## MEMORANDUM

Attention:	<b>Jonathan Upson</b>	Date:	<b>19 August 2013</b>
Company:	<b>Infigen Energy</b>	Pages:	<b>1 of 9</b>
Email:	<b>Jonathan.Upson@infigenenergy.com</b>	Document No:	<b>50B-08-0089-GCO-790684-2</b>
From:	<b>Anton Steketee</b>	Reviewed By:	<b>Peter Teague Andrew Leonard</b>
Subject:	<b>Response to SKM Peer Review</b>

Re: **Response to SKM Peer Review**

Sinclair Knight Merz (SKM) have undertaken a peer review of the Flyers Creek Wind Farm Noise assessment and background monitoring conducted by Vipac, and associated responses to these reports by third parties. Vipac provide the following comments regarding the details requested by SKM to support the application.

**Figure 12.2 – Background noise at receiver (Residence 12) versus reference wind speed at wind farm**

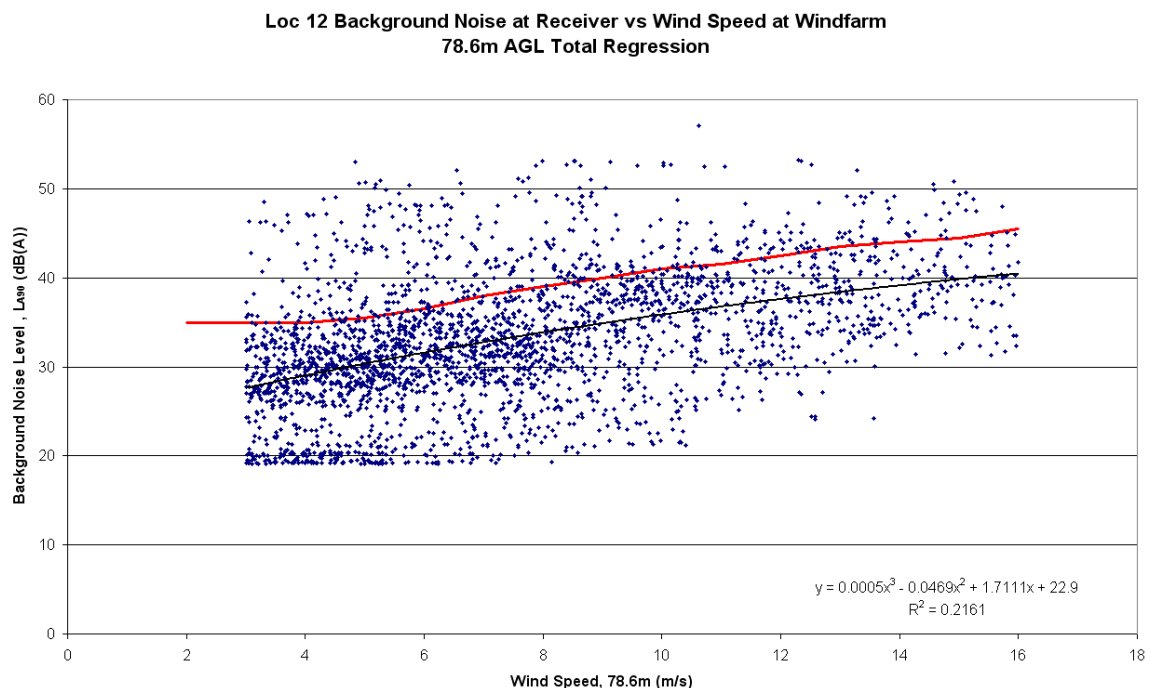
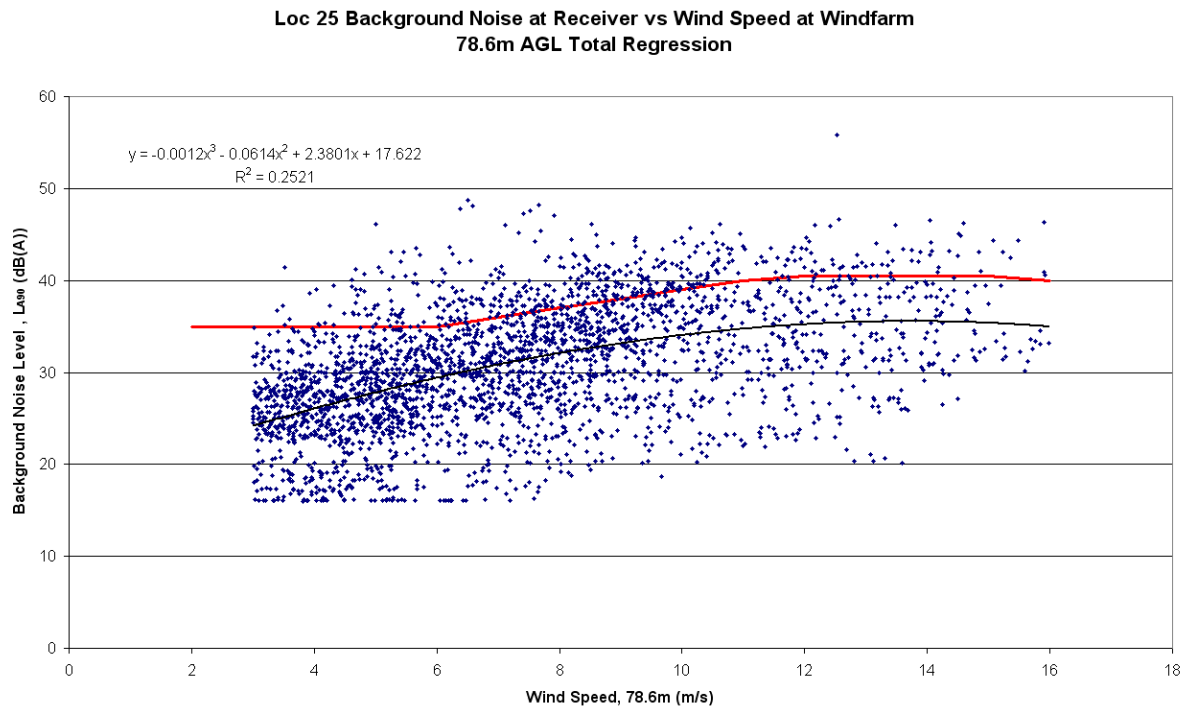
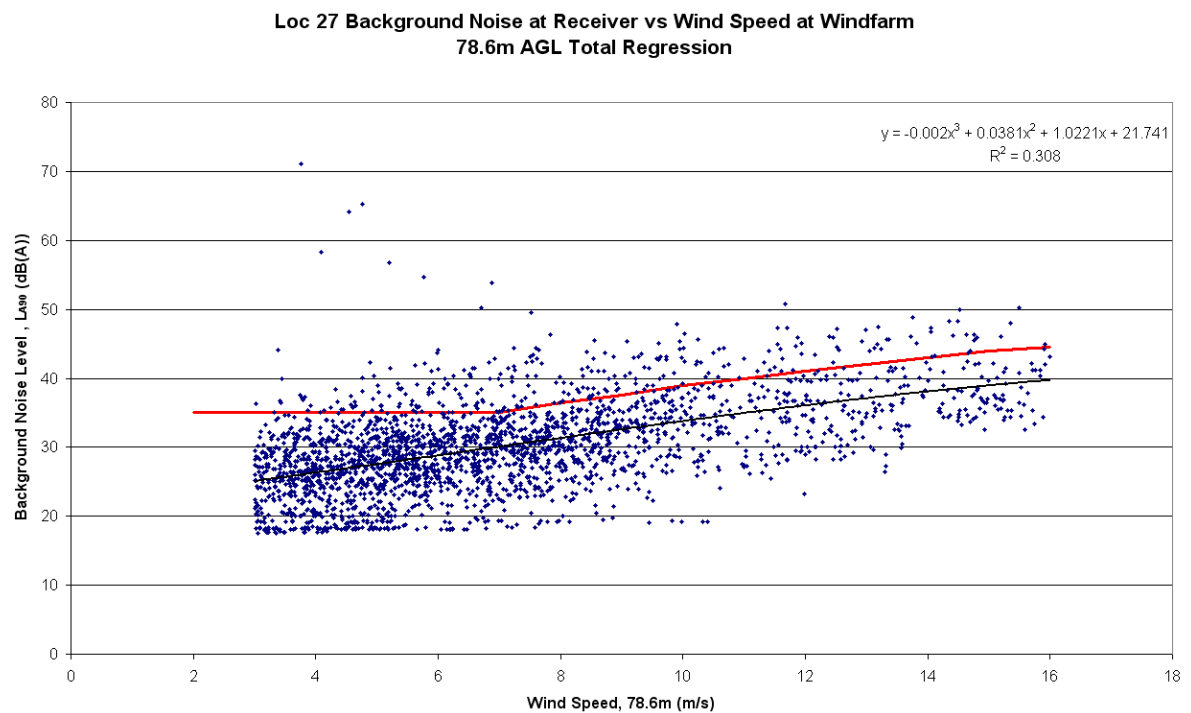
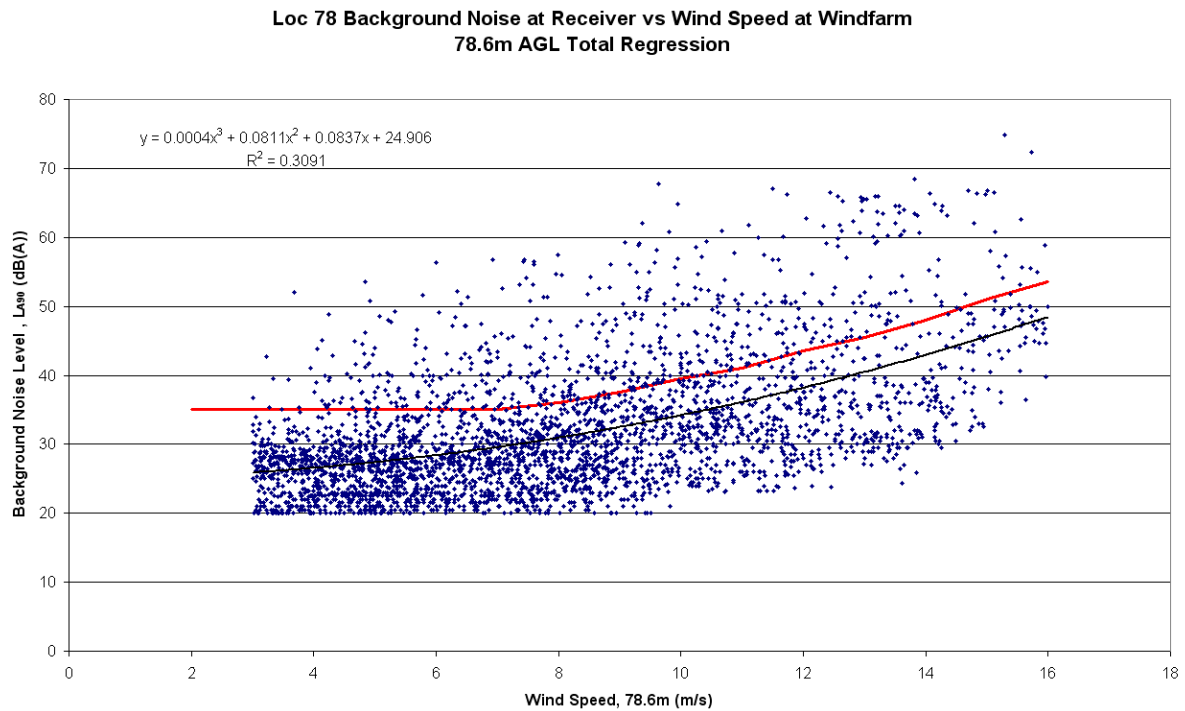
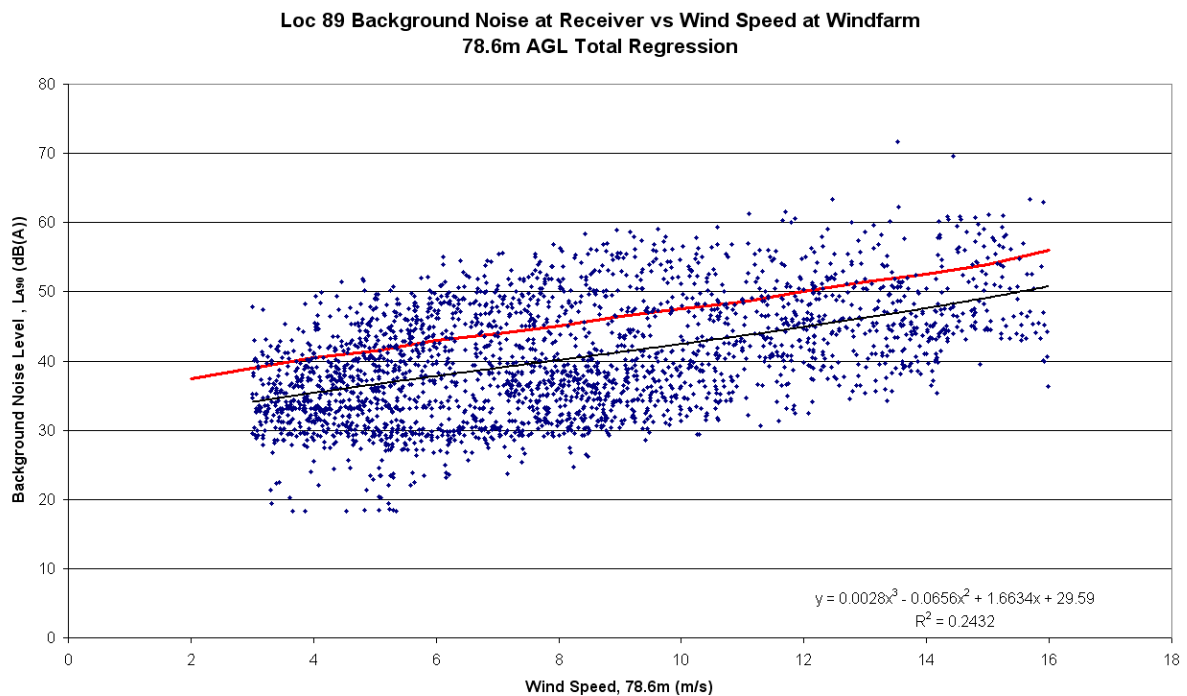
SKM have requested more details regarding the *small disparity between daytime and night time results* noted in Vipac’s Noise Impact Assessment (NIA) Report. For all monitored locations except R89, the day time average background noise levels are 3 to 5dB(A) higher than the night time levels at most wind speeds, with a larger disparity occurring at some locations at higher wind speeds, which may be exacerbated by having a smaller sample size at these wind speeds. Day time noise levels at R89 were only slightly higher than night time levels for windspeeds up to 9m/s (at hub height). It is typical that daytime noise levels are higher than night time noise levels and may be caused by an increase in noise due to traffic, people, animals during the day time near the monitoring locations and changes in wind shear between daytime and night time. SA03 does not require any separation of day time or night time background noise levels, therefore this difference will **not significantly affect** compliance with the requirements of SA03. It is however, noted in the Noise Impact Assessment Report as a matter of completeness.

SKM have also questioned the references to four and five monitored sites on page 7. Background noise monitoring was undertaken at five sites. As the noise levels measured at R89 were notably higher than all other sites, these noise levels were not used to determine criteria at any of the non-monitored locations. Therefore, background noise criteria were developed for non-monitored sites based on four of the monitored sites as discussed in paragraph 2 on page 7 of the NIA report.

Table 5-3 in the NIA provides noise criteria for each monitored site for 3 – 9 m/s windspeeds (at 10m AGL). (which is approximately 4-12.5 m/s at hub height) SKM suggest that an additional two wind speeds are required to achieve the full range of required wind speeds, from cut in to rated power required by SA03. However, 3 m/s is the cut in windspeed and 9 m/s **is wind** speed (at 10m AGL) required to achieve rated power [5] and therefore meets the requirements of SA03.
